Title: **STAGE 1 QUALITY AUDIT**

Sandyford Central.

Date: **September 2019**

Report reference: **0653R01**

Client:	Sandyford GP Limited							
Project:	Sandyford Central							
Title:	Roads Layout Sheet 1 of 2							
Code	Originator	Zone	Level	Type	Role	Number	Status	Revision
SFC	OCSC	00	00	DR	C	0001	A1	C03
Date:	22.05.19 Scale: 1:150 @ A1 Drn by:SMG Chkd by:PR Aprvd by:AH

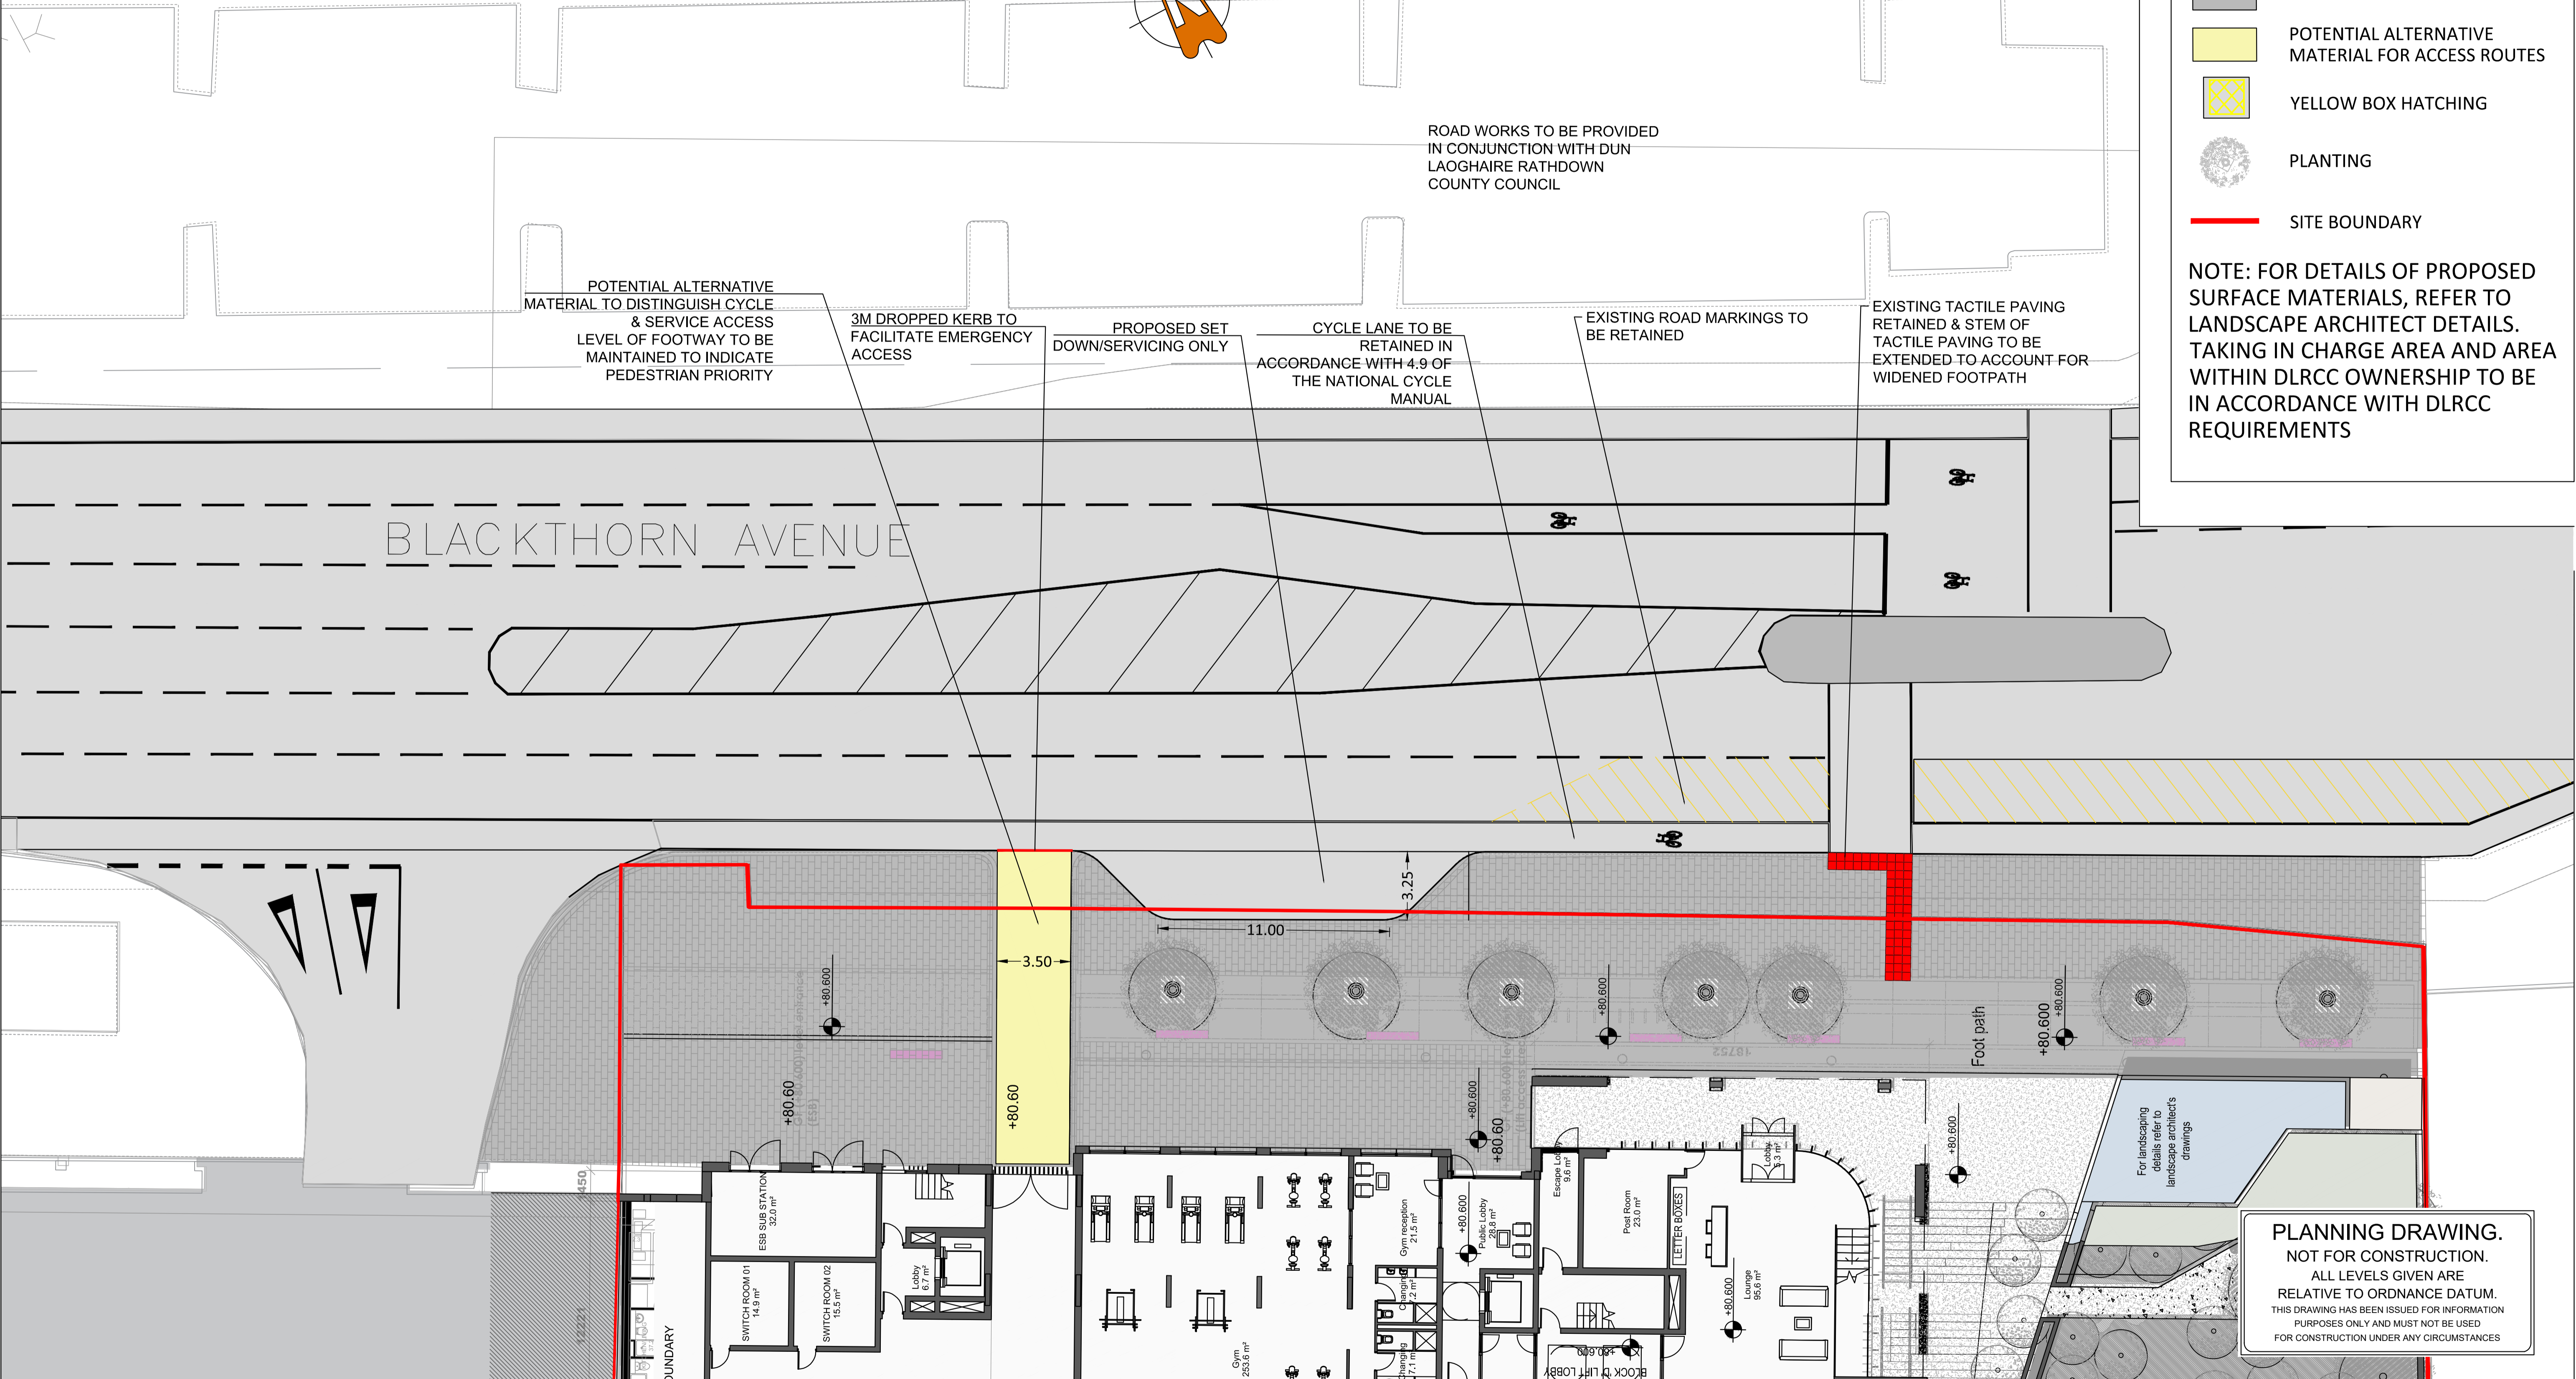
Drawing SFC-OCSC-00-00-DR-C-0001 A1, C01

There are inadequate crossing facilities for pedestrians wishing to cross the car park to the West of the proposed development on Blackthorn Avenue. Without suitable tactile paving, partially sighted pedestrians may inadvertently enter the carriageway resulting in a greater risk of a collision with vehicular traffic.

The existing crossing has black (pavement) and white strips that may make it look like a zebra crossing however it is an uncontrolled crossing. This may lead to pedestrians thinking that they have right of way over vehicular traffic and may enter the crossing without due caution.

There are existing tactile paving slabs and dropped kerbs at the Blackthorn Avenue edge of the existing footpath. This may lead pedestrians to cross here where it is not as safe as crossing at a greater setback given the width of the car park access.

It is recommended that the crossing is upgraded to a zebra crossing or that the white strips are removed.

It is further recommended that the appropriate tactile paving is provided.

Lastly, it is recommended that the existing tactile paving at the carriageway edge be removed and a full height kerb be provided to deter pedestrians from crossing at that location.

Paragraph No. In Quality Audit Report	Problem accepted (yes/no)	Recommended measure accepted (yes/no)	Alternative measures (describe)	Alternative measures accepted by Auditors (Yes/No)
3.1	Yes	No	This is within the boundary of the adjacent development and is outside the scope of works of this project.	Yes, Issue for Roads Authority
3.2	Yes	No	There is no proposal to amend the adjacent roads as part of this development, this area is outside the scope of this project.	Yes, Issue for Roads Authority
3.3	Yes	Yes		
3.4	Yes	Yes		
3.5	Yes	Yes

Title: Roads Layout  
Sheet 2 of 2

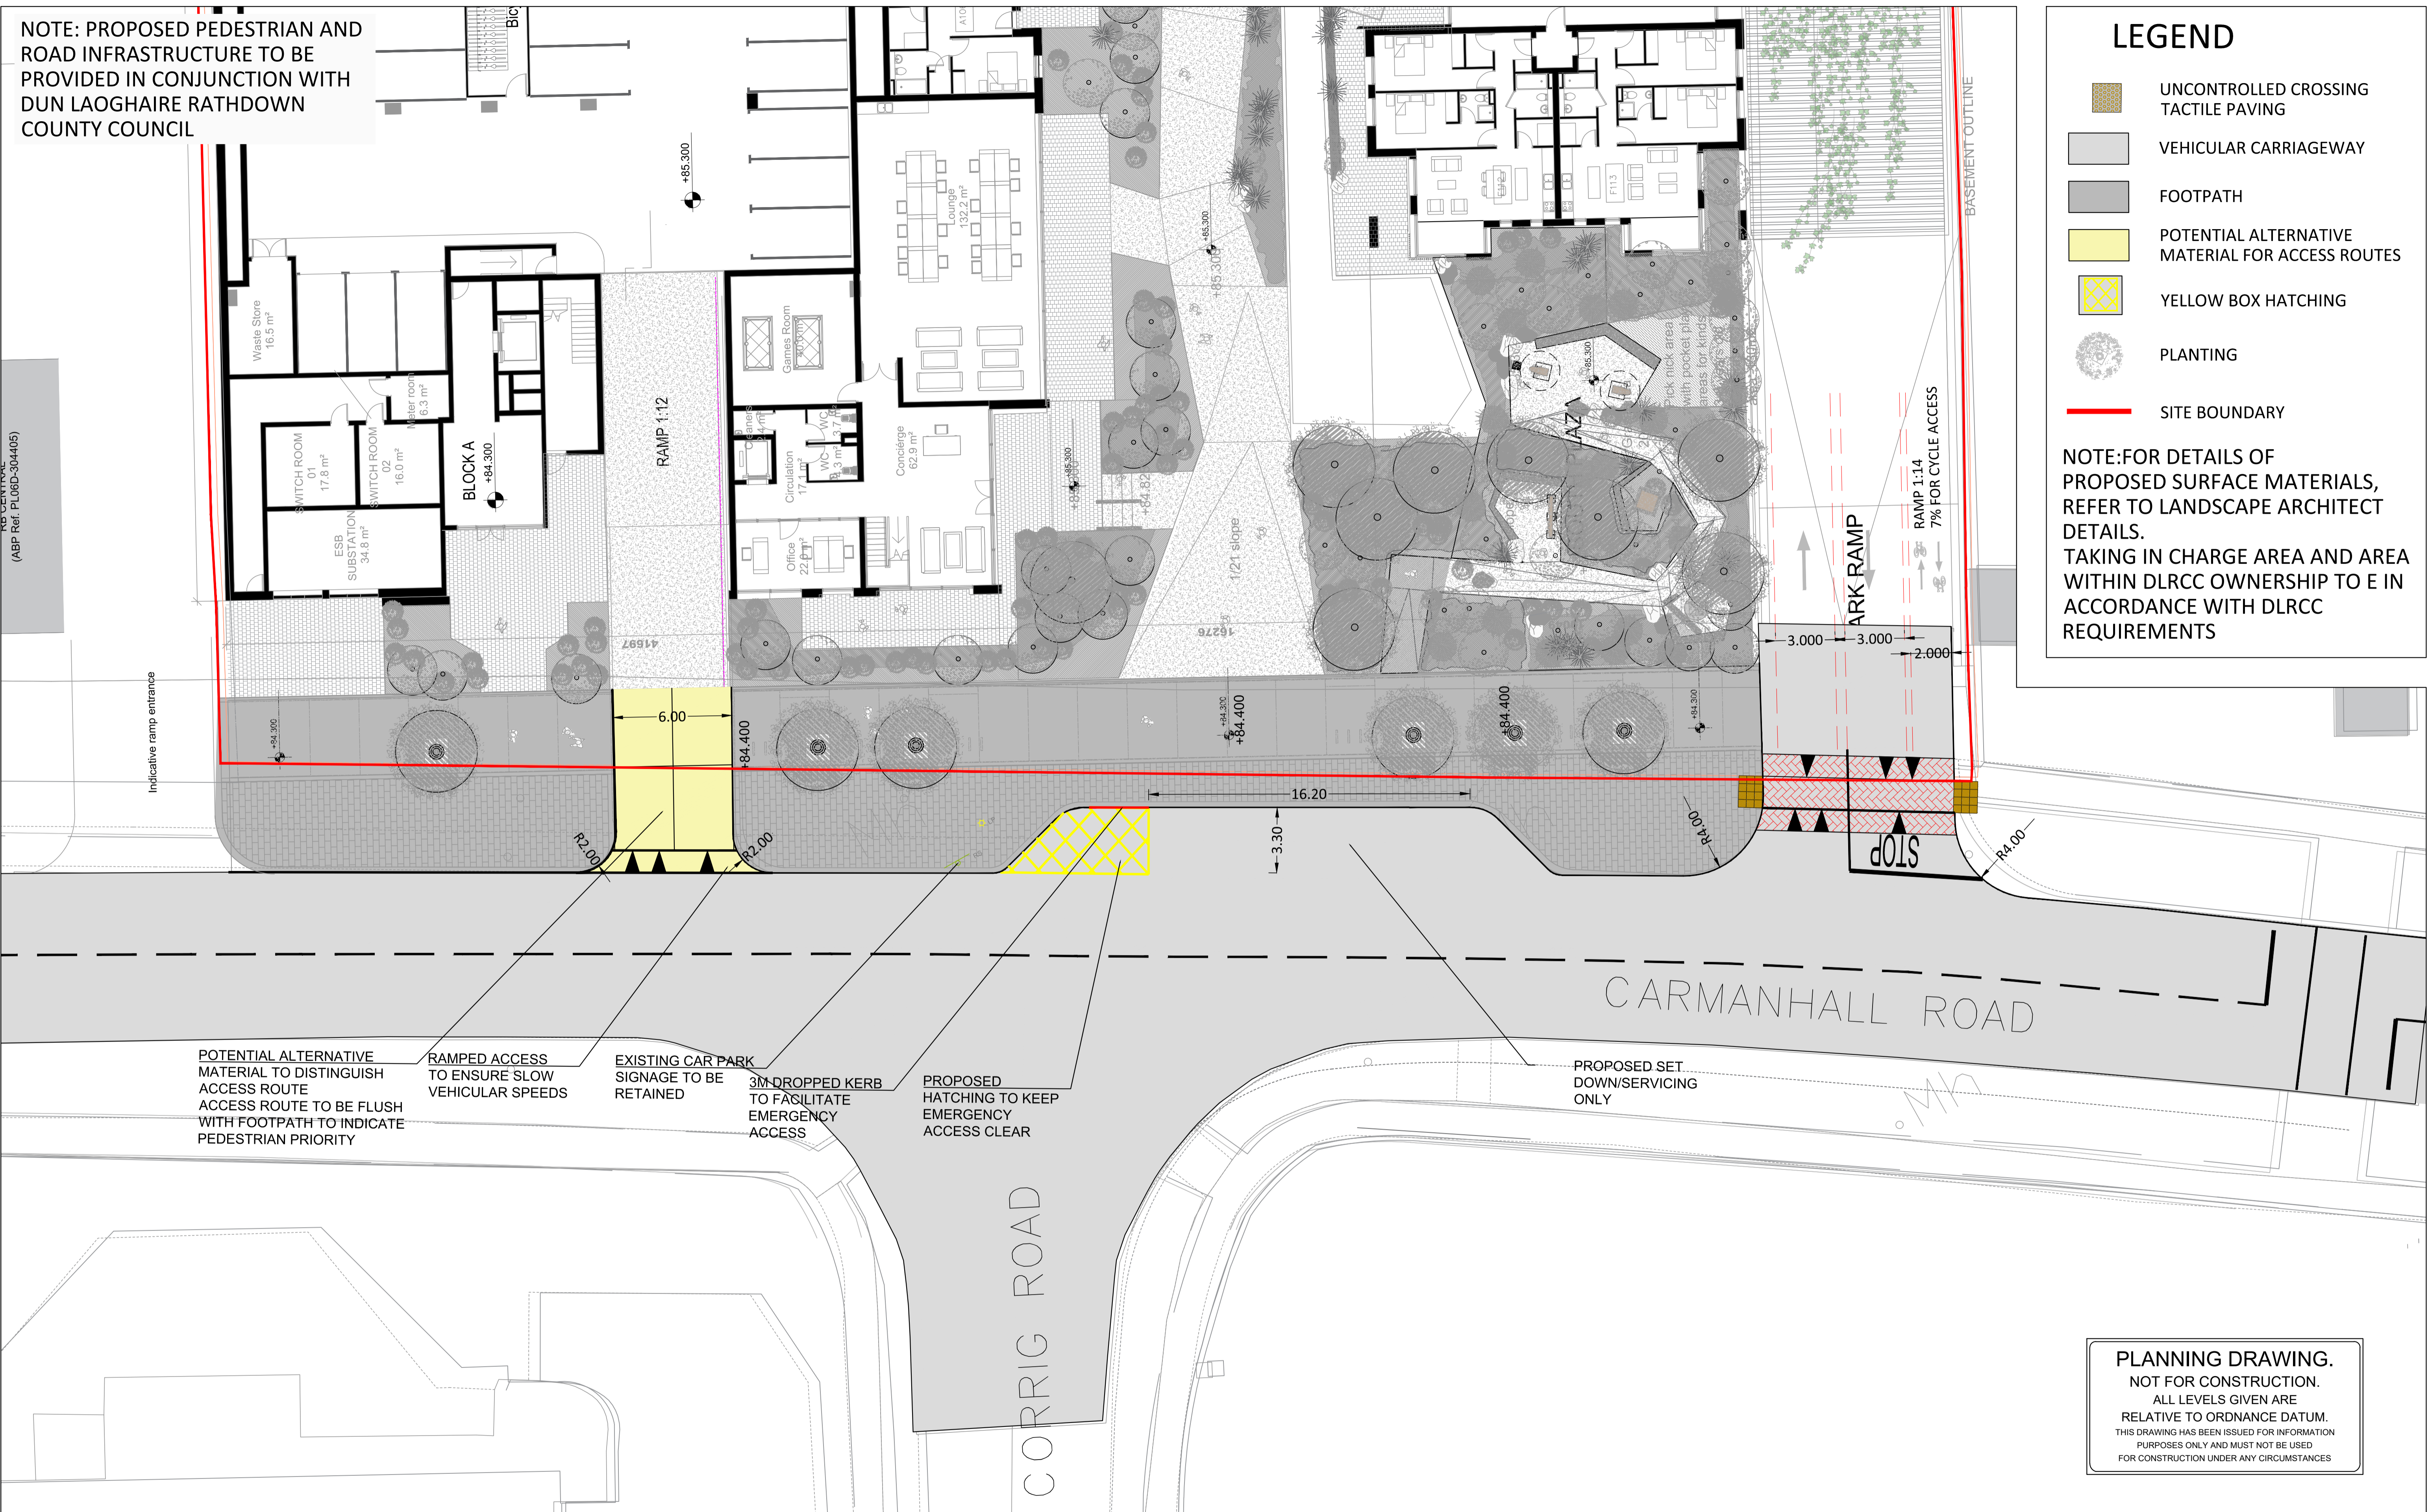
Drawing SFC-OCSC-00-00-DR-C-0002 A1, C01

There is an existing advisory cycle lane on northern side of Carmanhall Road to the West of the proposed development. There are no facilities for cyclists along the site boundary. The lack of cycle facilities will lead to drivers being less aware of the presence of cyclists and a greater risk of collisions between the road user groups.

It is recommended the cycle lane be continued along the front of the development to the existing signalised toucan crossing East of the proposed site.

Drawing SFC-OCSC-00-00-DR-C-0002 A1, C01

The drawing shows tactile paving at the crossing of the access to the basement on Carmanhall Road. This is an in-line crossing and there is a risk that blind or partially sighted pedestrians may step over the tactile paving and inadvertently enter the carriageway where they would be at greater risk of being struck by a vehicle.

It is recommended that the tactile paving for in-line crossings be at least 1.2m deep.
